CITY OF ALBUQUERQUE

May 19, 2009

Re: Approval of Temporary Certificate of Occupancy (C.O.) for
Cube Restaurant, [K-15 / D085]
1520 Central Ave. SE
Architect's Stamp Dated 05/19/09

Re: The Cube Restaurant, Engineer's Stamp Dated 12-28-06
1520 Central SE, (K15/D85)

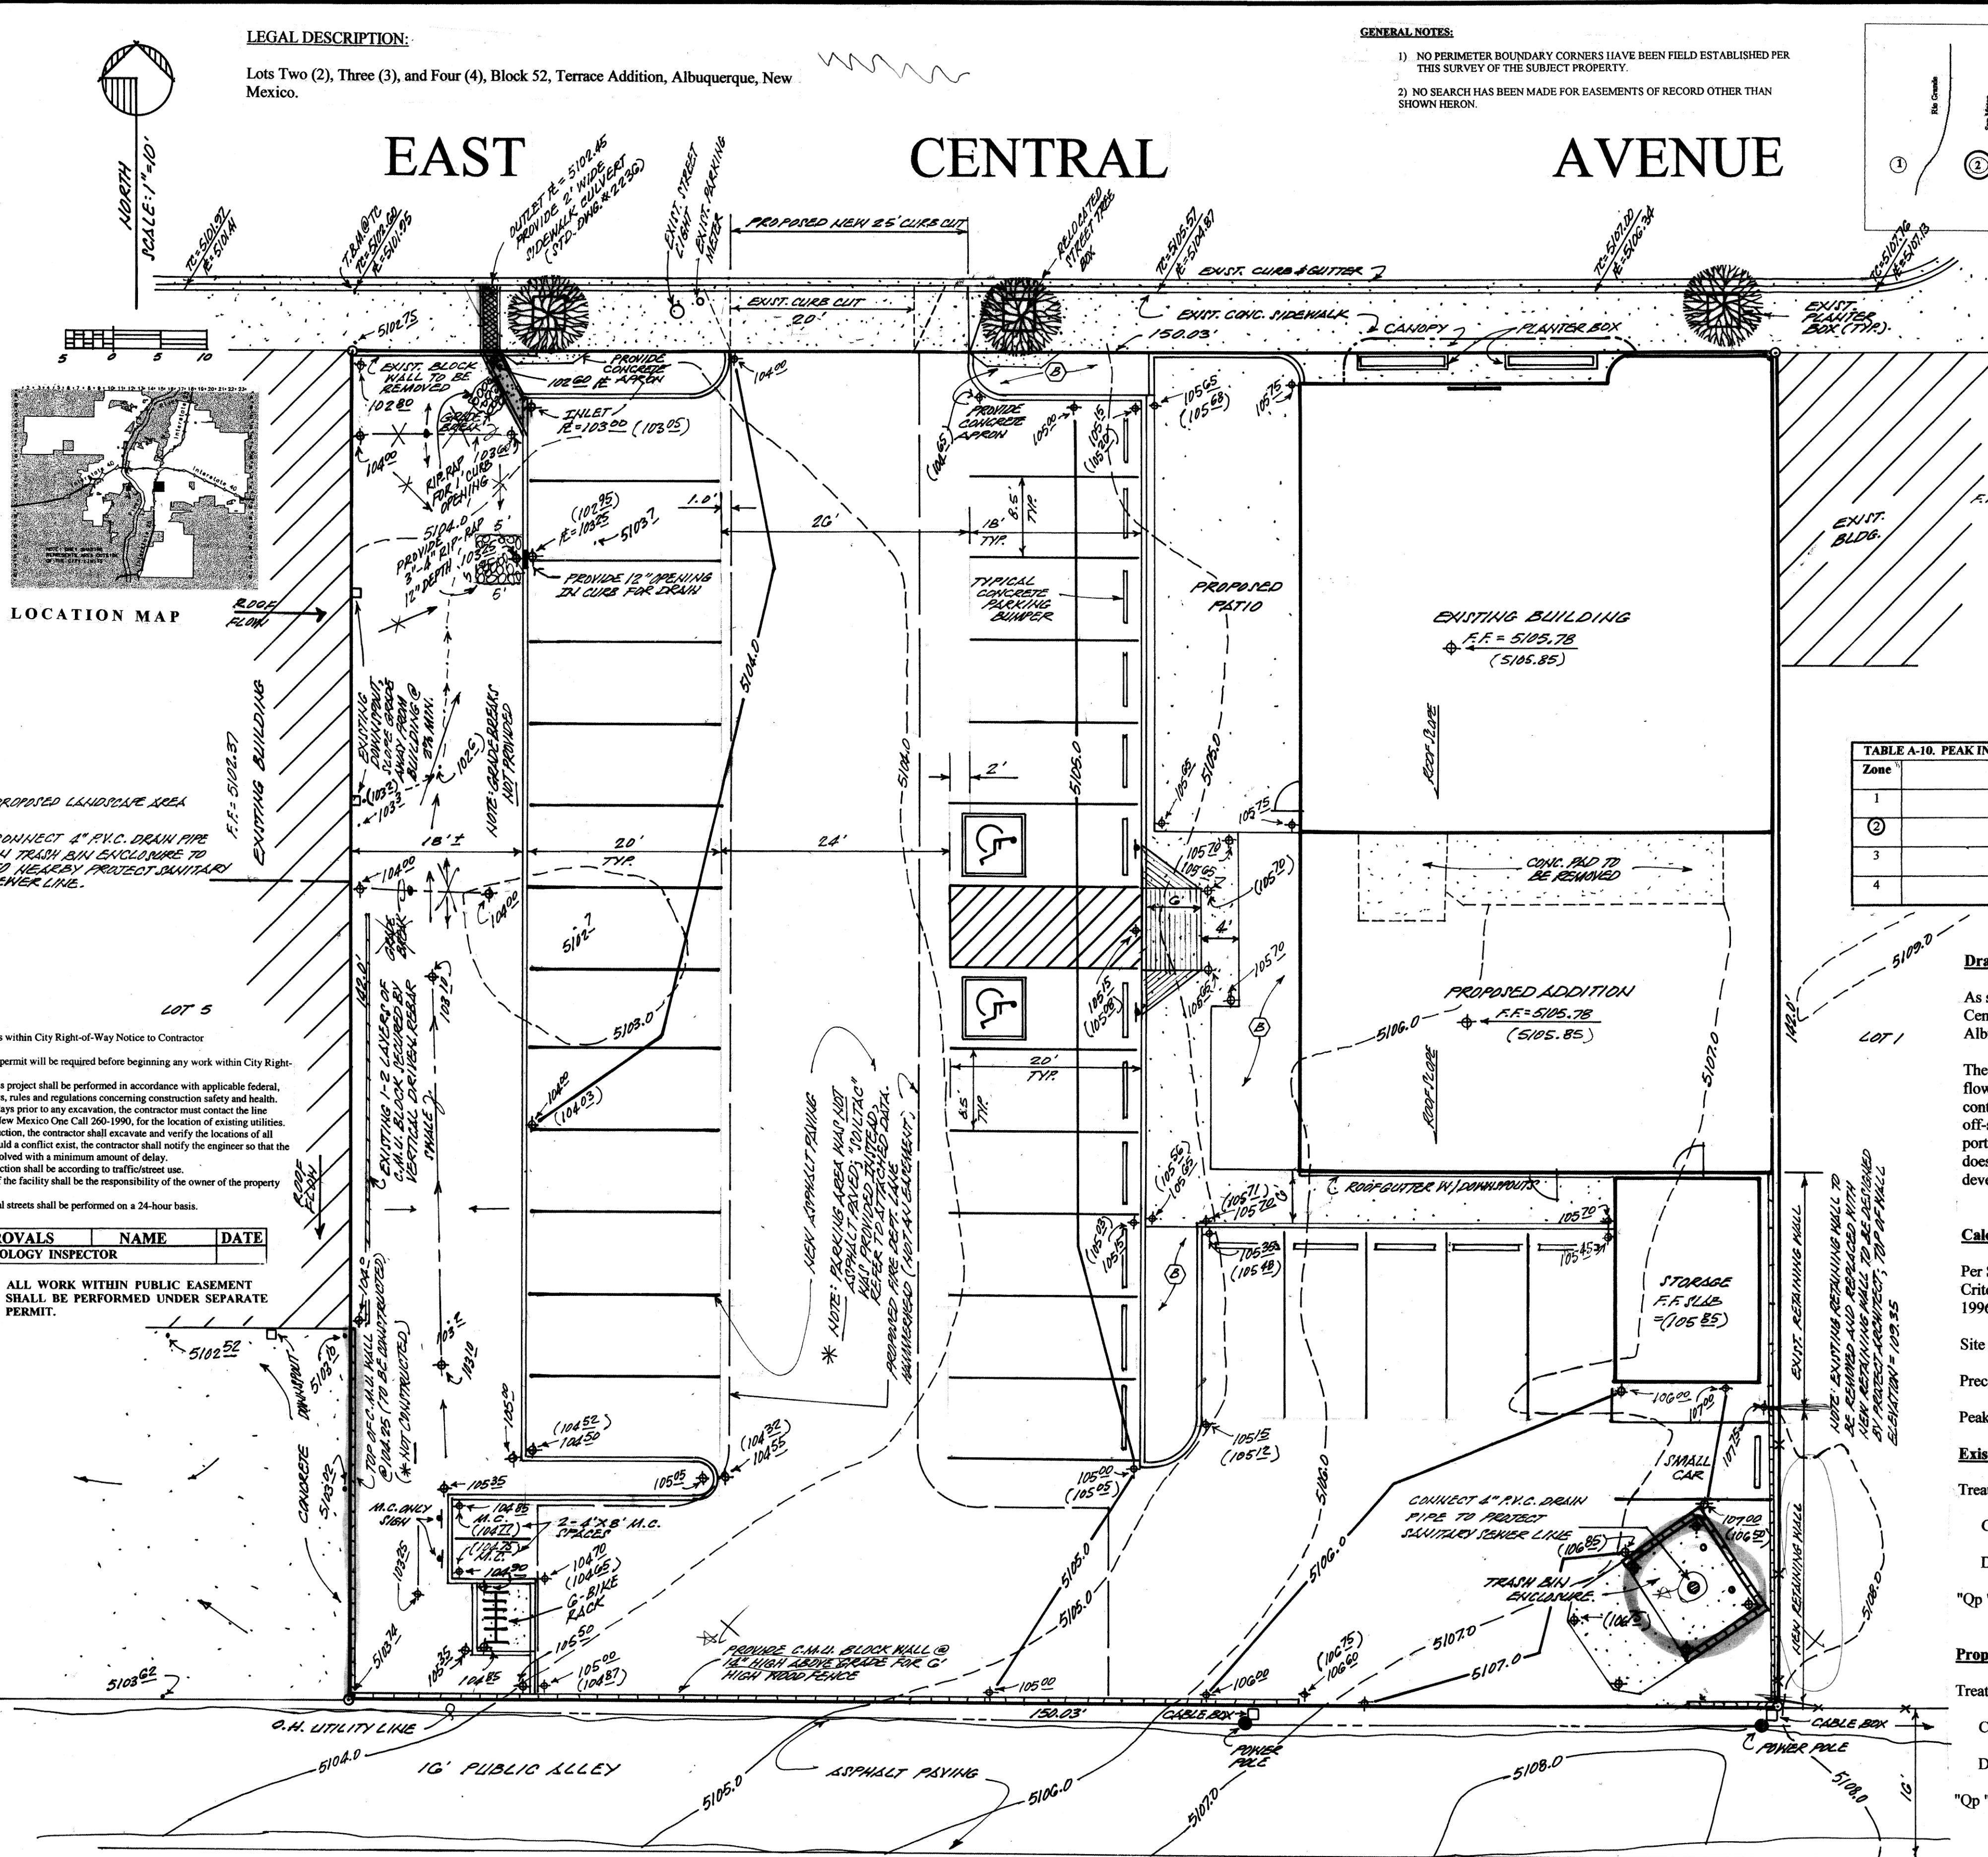
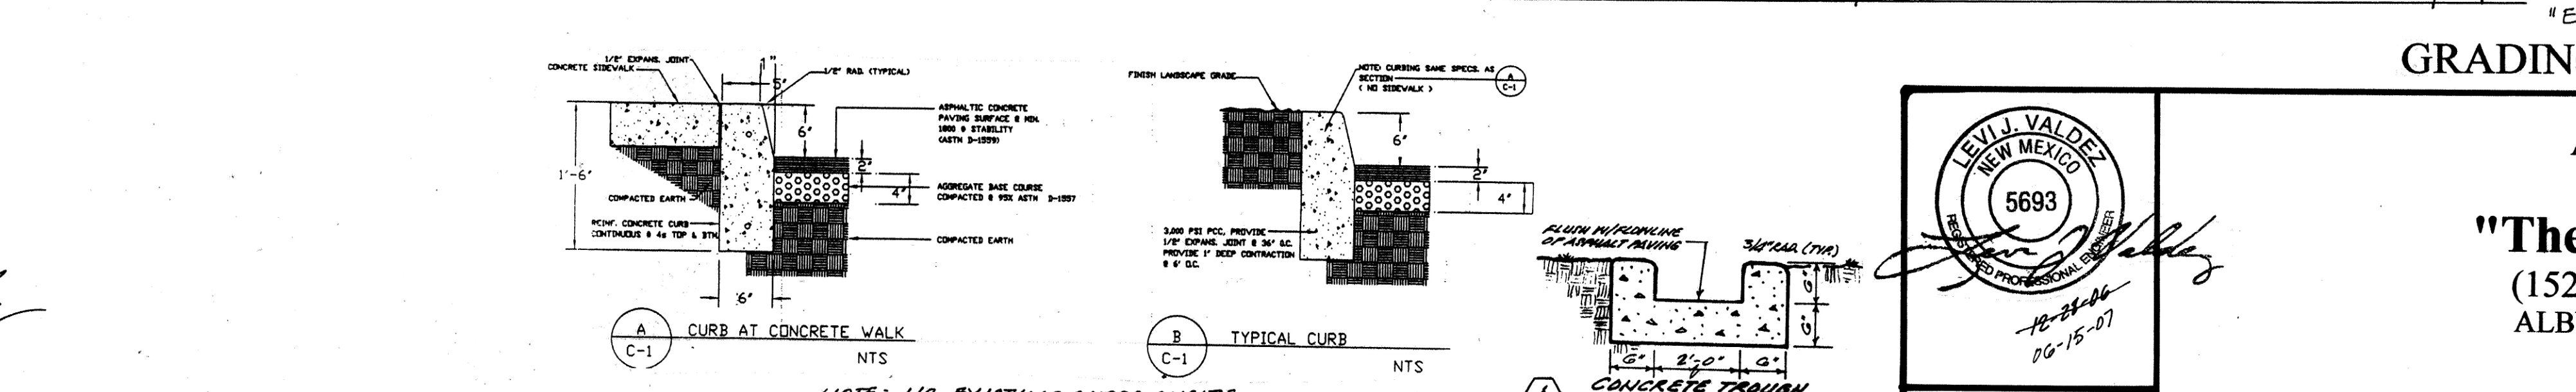
- Please revise the northwestern corner spot elevation on the dumpster pad to 7.15 so as to be consistent with the other three (3) corner points and retain runoff within that structure.

- The trough width (1-foot) shown on your detail 'A' does not agree with the general notes (2-feet) associated with the proposed sidewalk culvert.
- The slope for the proposed on-site handicap ramp (8.3%) does not agree with the same slope shown on the handicap parking detail (10%). The note for the curb section on this drawing references detail 1/C-1. Is this supposed to A/C-1 or B/C-1?

- Please differentiate between what curb exists on-site (if any) and what is proposed. Separate line types and legend entries may be appropriate.
- What does the hatching on the west side of the storage building represent? Will there be curb along these southern parking spaces as is the case with the rest of the parking lot?

- Due to the high traffic volume on Central, you may be required to install curb returns (and subsequently handicap ramps) at the northern entrance. Please contact our Traffic Engineer, Wilfred Gallegos at 924-3991 to confirm.

Although not a specific requirement for Building Permit approval by this office, you may want to consider enlarging the dimensions and flattening the slopes of the on-site ramp to more closely resemble the attributes of standard drawing #2441. This could reduce the potential future risk of liability for your client.
